Your Ref: OWPC16404
Our Ref: LU/355/17/HH 20-10-2017
Please ask for:
Ross Leal

Town & Country Planning Act 1990 (as amended)
Town & country Planning (Development Management Procedure) (England) Order 2015

Single storey side extension to form annexe ancillary to main dwelling.
16 Madehurst Way Littlehampton

DRAWING	SCALE
PLANNING	1/100
DATE: OCTOBER 2017	
DRAWN: T. Murray	
DRAWING: 17/46/2	REVISION:

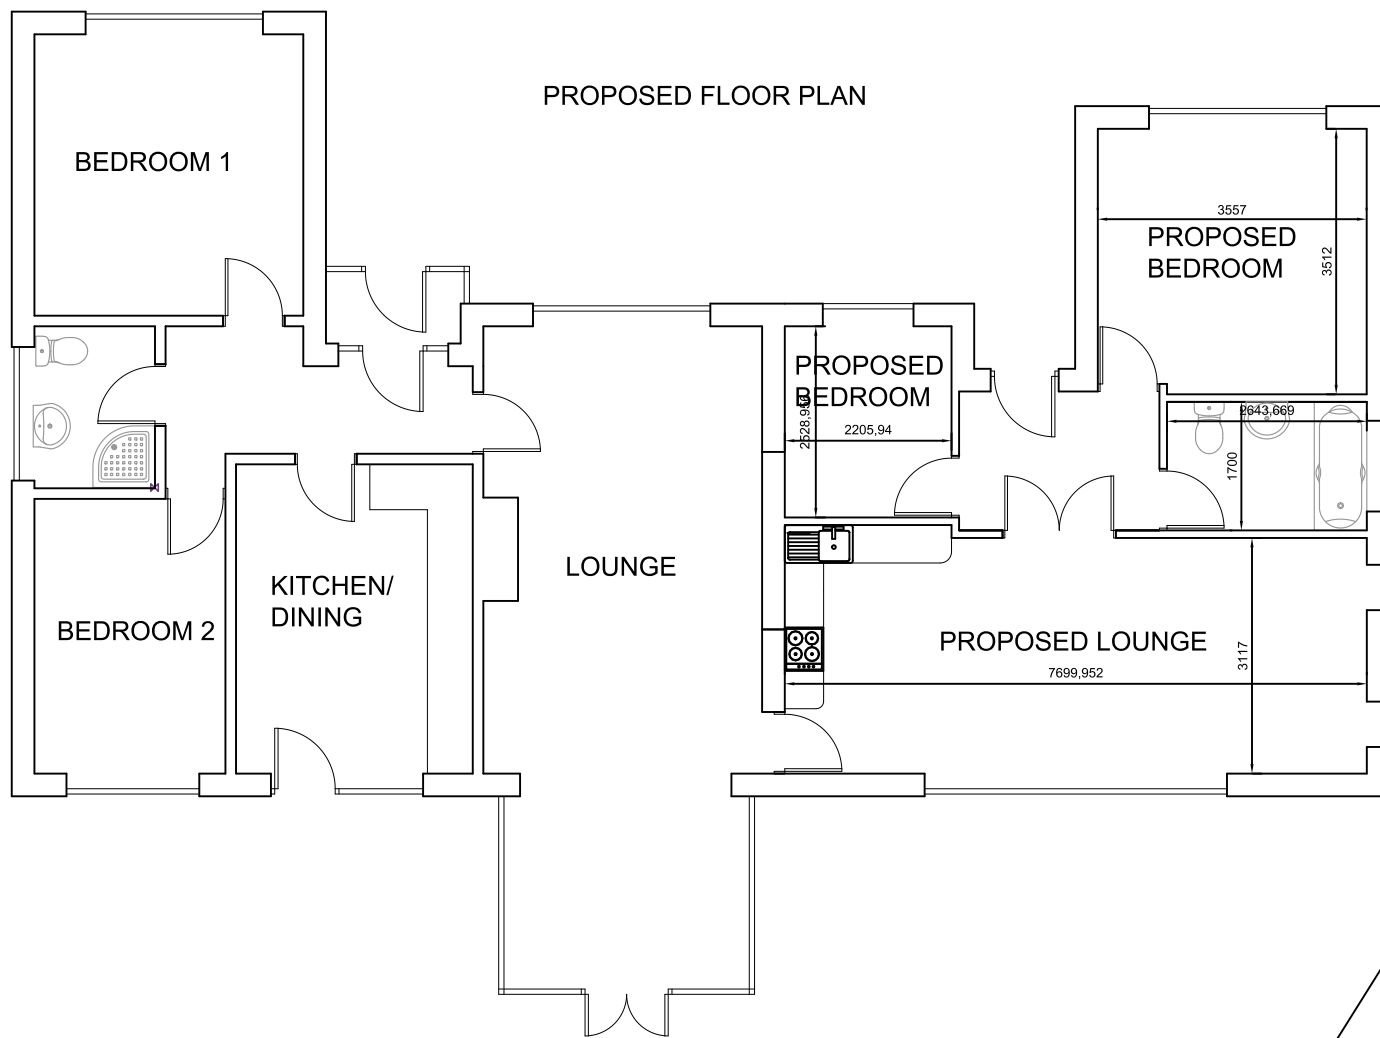
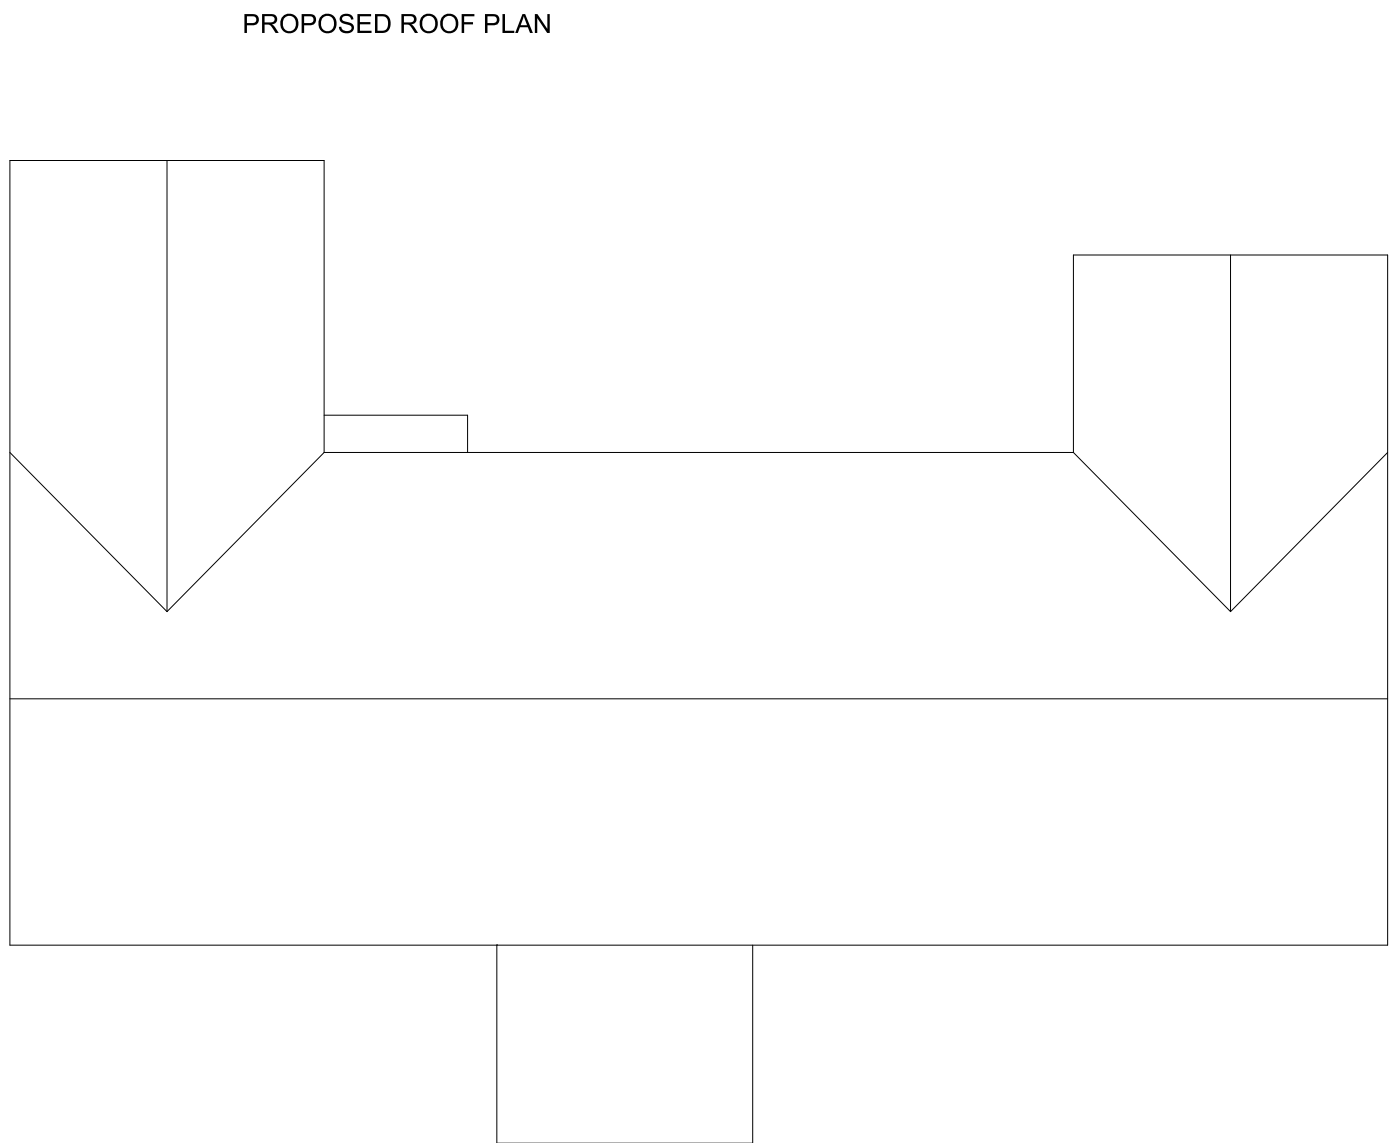
The waste from number 16 passes into 2 drains on my property which cross my back garden (and the back garden of number 12) to access the main drain. The plan of the existing property at number 16 appears to be incorrect as it only includes one access point into the drain however there are two - the second (not shown) is from the bathroom which connects into the drain outside my kitchen door at number 14.

The proposed annexe is a large addition which would seem to make the total size of the property twice what it is currently. The existing drains are old and were laid to support the properties initially built in the 1960s. Given the proposed increase in size and facilities at number 16, I would like assurance that the existing drains would be adequate to cope with additional capacity or, should this not be the case, that I would be indemnified against the cost of any future drainage issues. I have recently spent a considerable amount of money on garden works at my property and would not wish to have this compromised. Alternatively a direct link from the proposed build into the main drain could conceivably circumvent any potential risk.
